DRB Application No.: 06DRB-01417 (ASBP)	Project # 1005179
Project Name LOS VOLCANES FITNESS CTR	
Agent: MAHLMAN STUDIO ARCHITECTURE	Phone No.: 243-0101

DEVELOPMENT REVIEW BOARD – SPEED MEMO

4. Project # 1005179

MAHLMAN STUDIO ARCHITECTURE agent(s) for CITY OF ALBUQUERQUE OFFICE OF SENIOR AFFAIRS, request(s) the above action(s) for all or a portion of Lot(s) 1-A-2, ATRISCO BUSINESS PARK, UNIT 2 (to be known as **LOS VOLCANES FITNESS CENTER**) zoned SU-1 FOR SENIOR CENTER, located on LOS VOLCANES RD NW, between AIRPORT NW and COORS NW containing approximately 3 acre(s). (J-10)

**PLANT SCHEDULE**

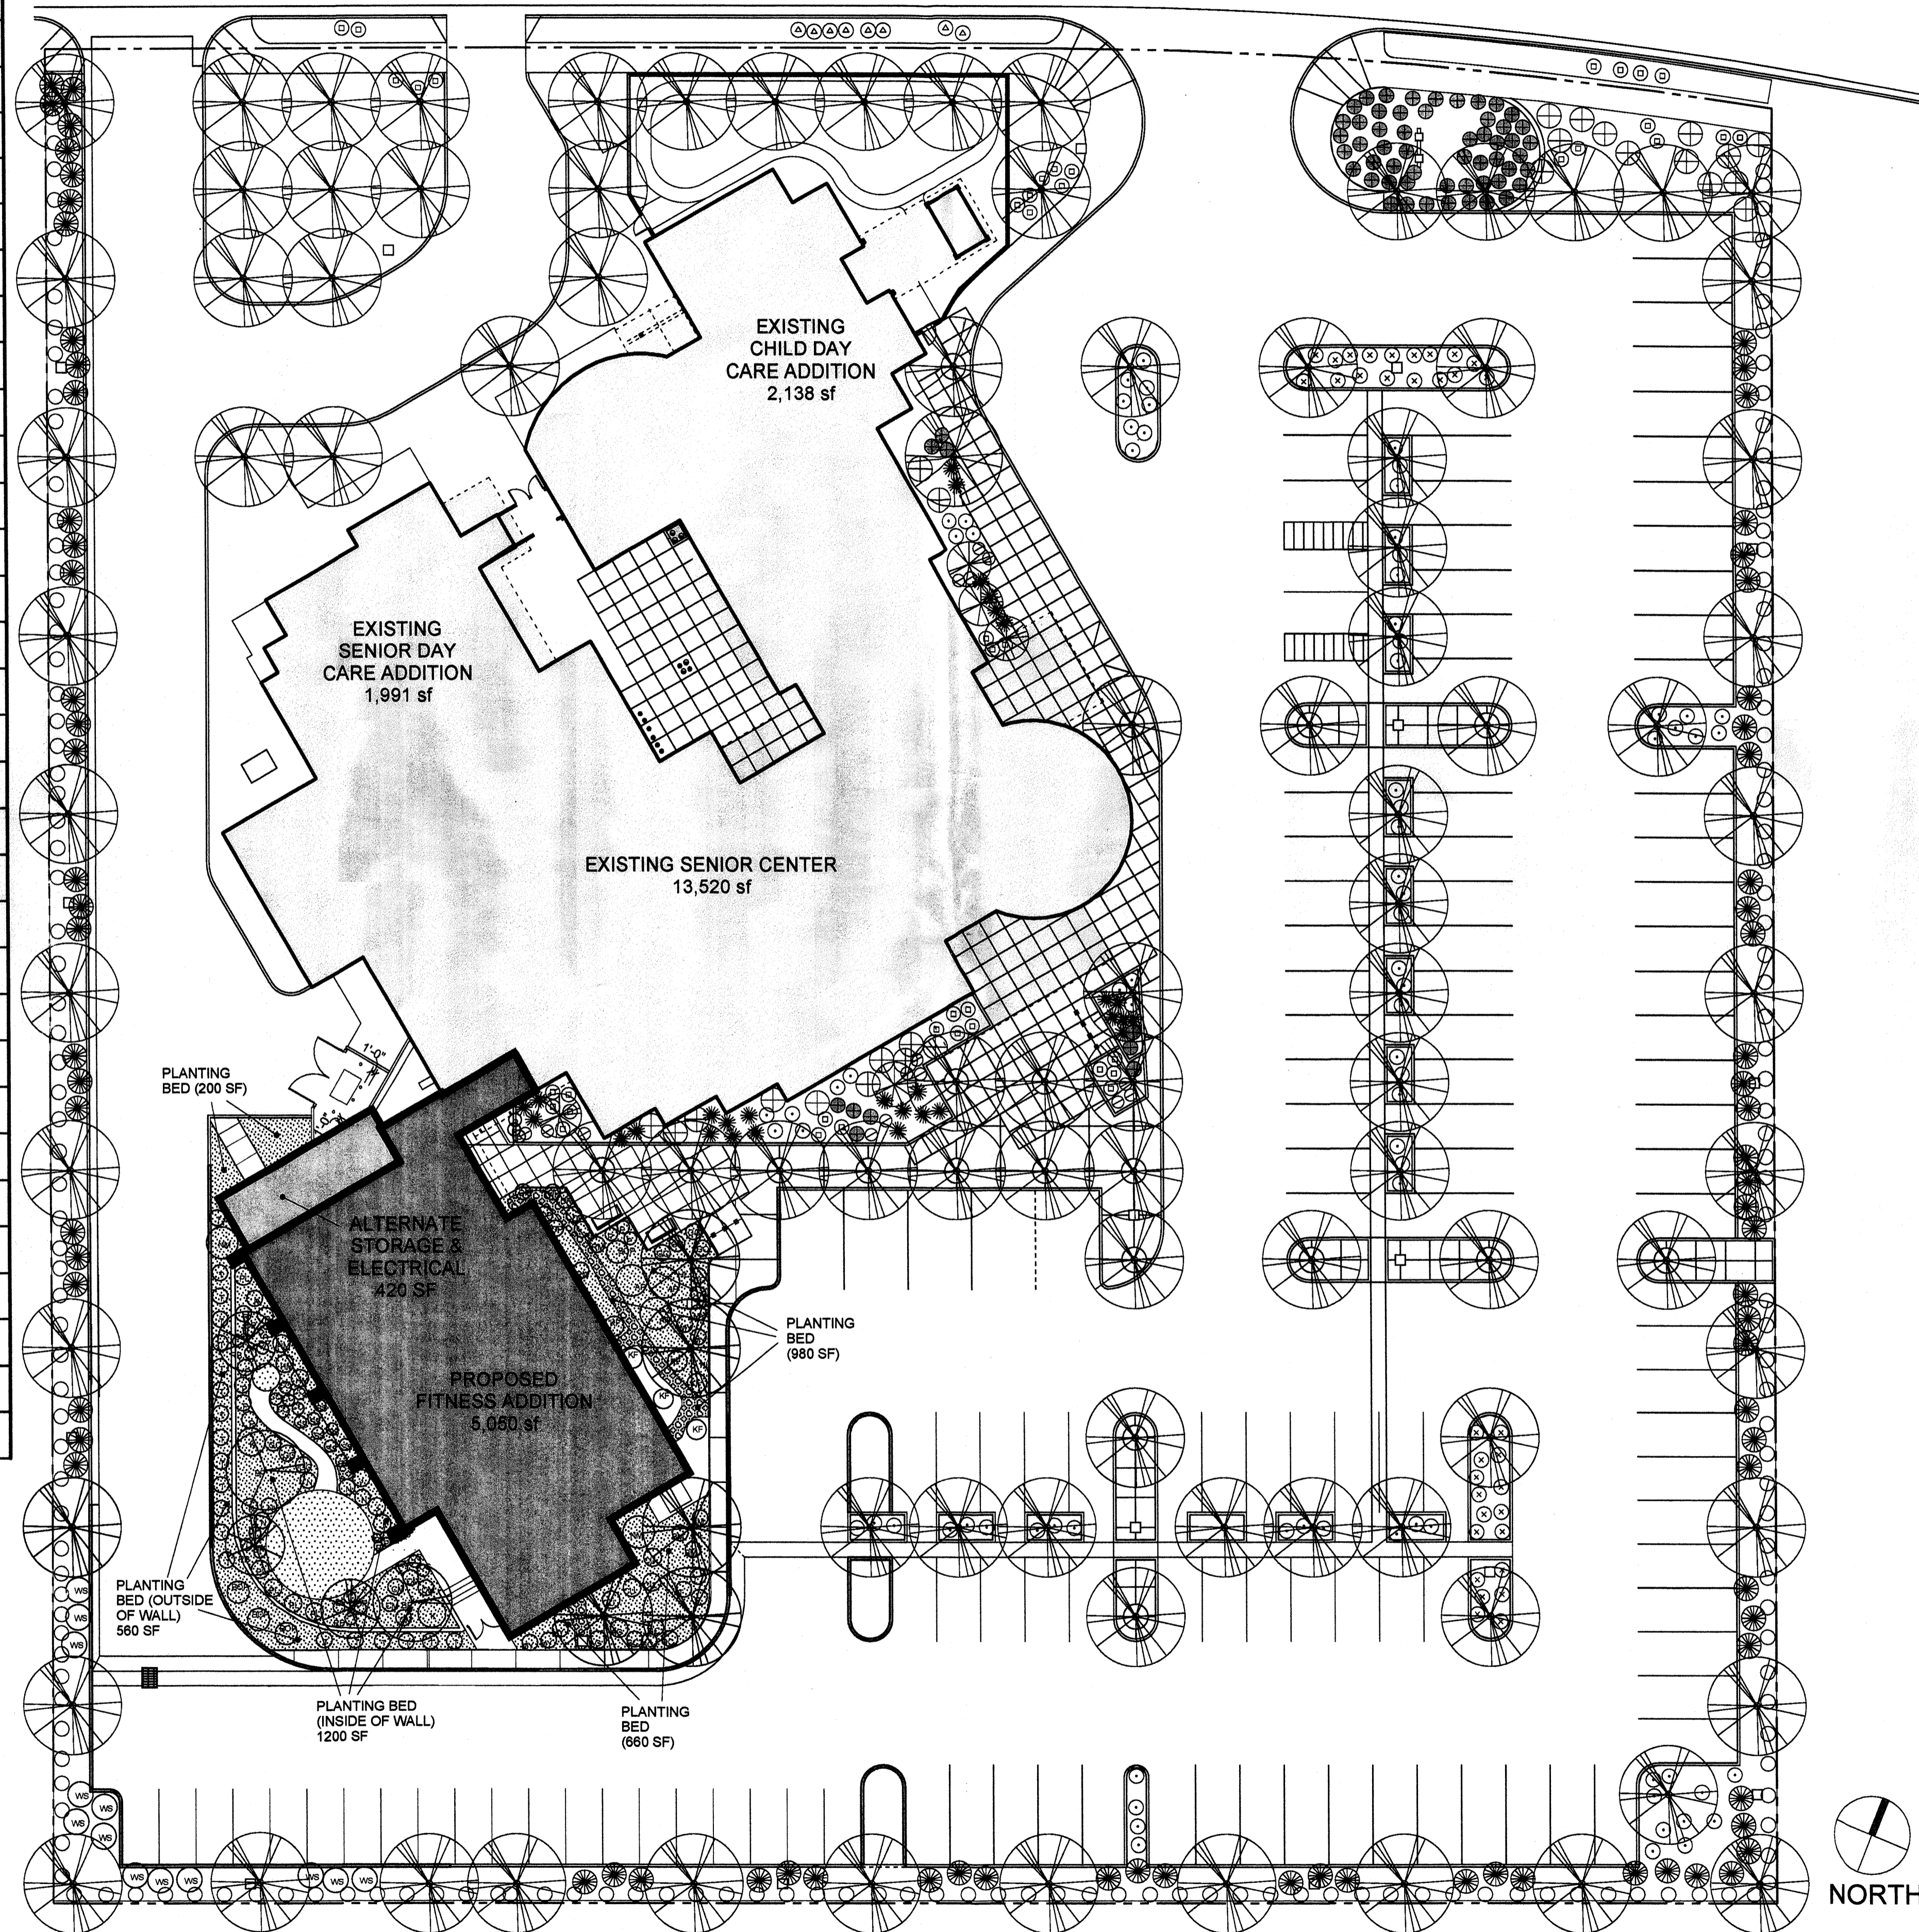
The Plant List should include the water usage for each plant. (H,M,L)

**PLANT SCHEDULE**

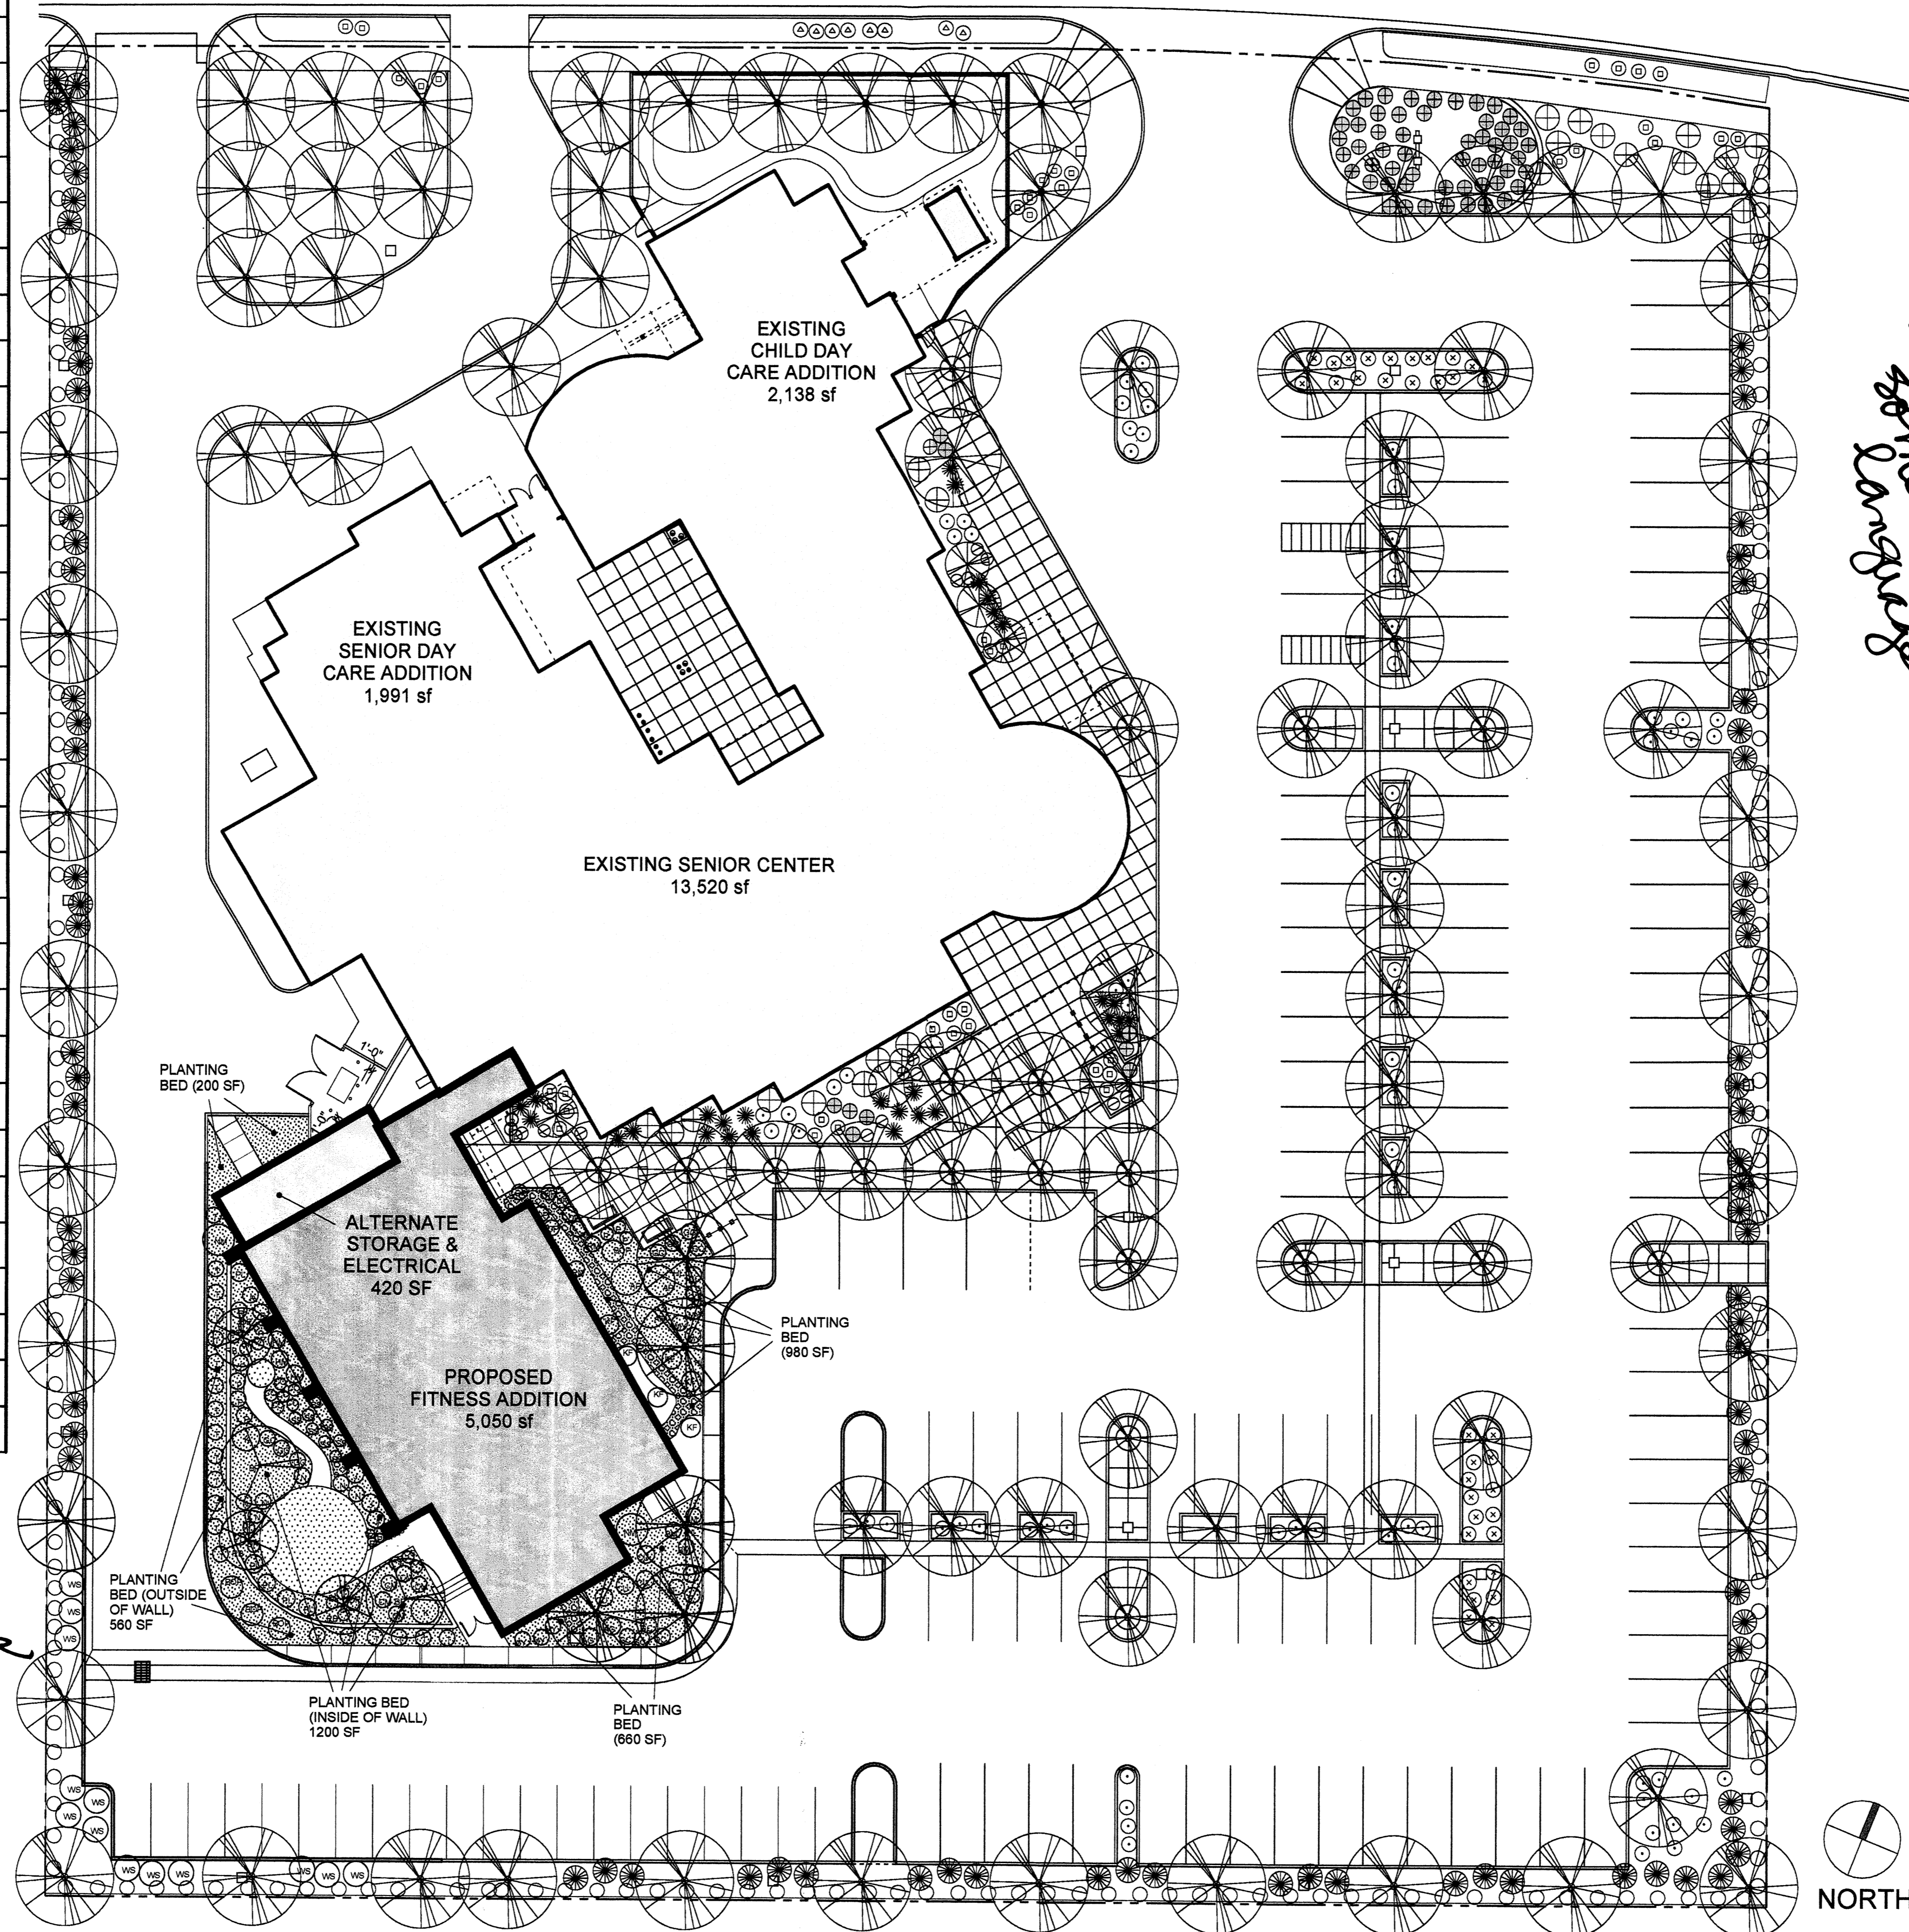
The percentage of landscaping provided is missing.

There is also some required language missing from the Landscape Plan:

**SITE PLAN**

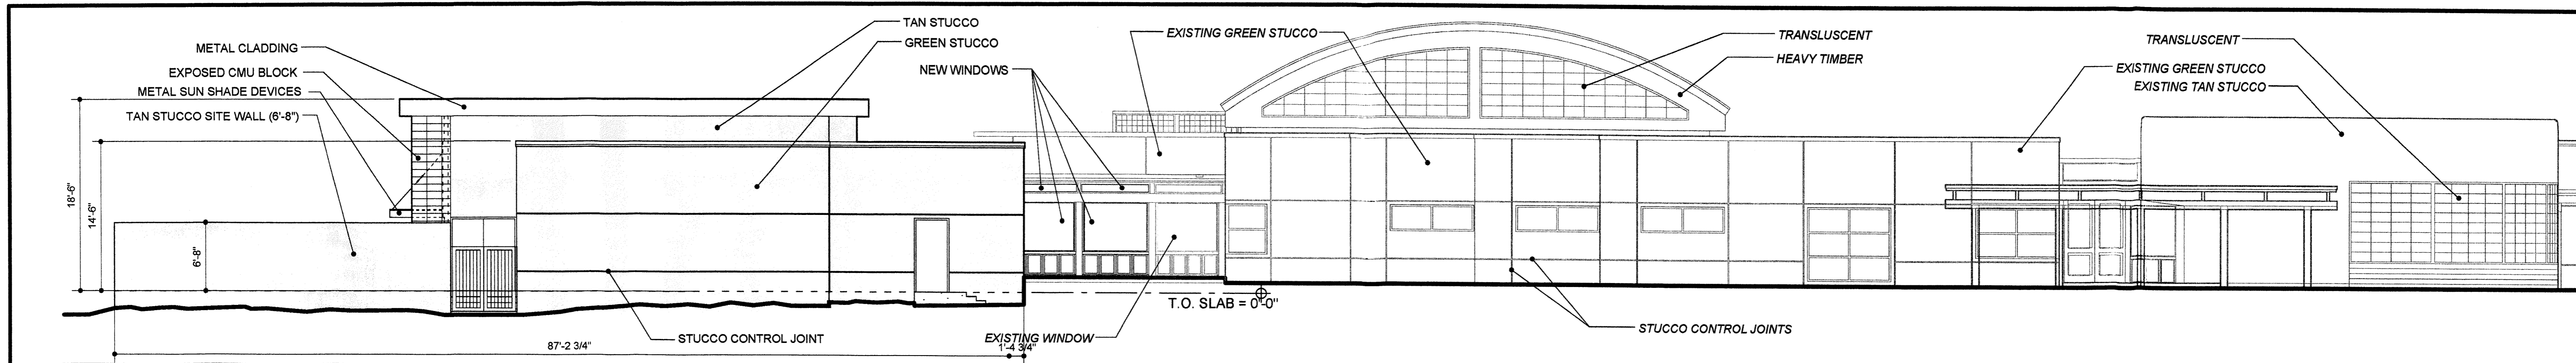
Is there a public sidewalk easement for the sidewalk along Los Volcanes? What is the width of the sidewalk? Has the EPC approved a reduction in parking required? Compact spaces are required to be 8' wide. Where are the aisles required for the ADA parking stalls? What are the new curb radii?

Because this is an amendment of an existing DRB approved site plan that is going to DRB for hearing, some modification to the signature block and site plan sheet title is needed.

Please change the site plan sheet title to "Amended Site Development Plan for Building Permit".

If there are any existing or proposed easements located within the boundaries of this property, please indicate what and where they are on the site plan & landscape plan per the SPBP Checklist.

Please darken the property lines on the site plan and landscape plan so they are clearly identifiable.
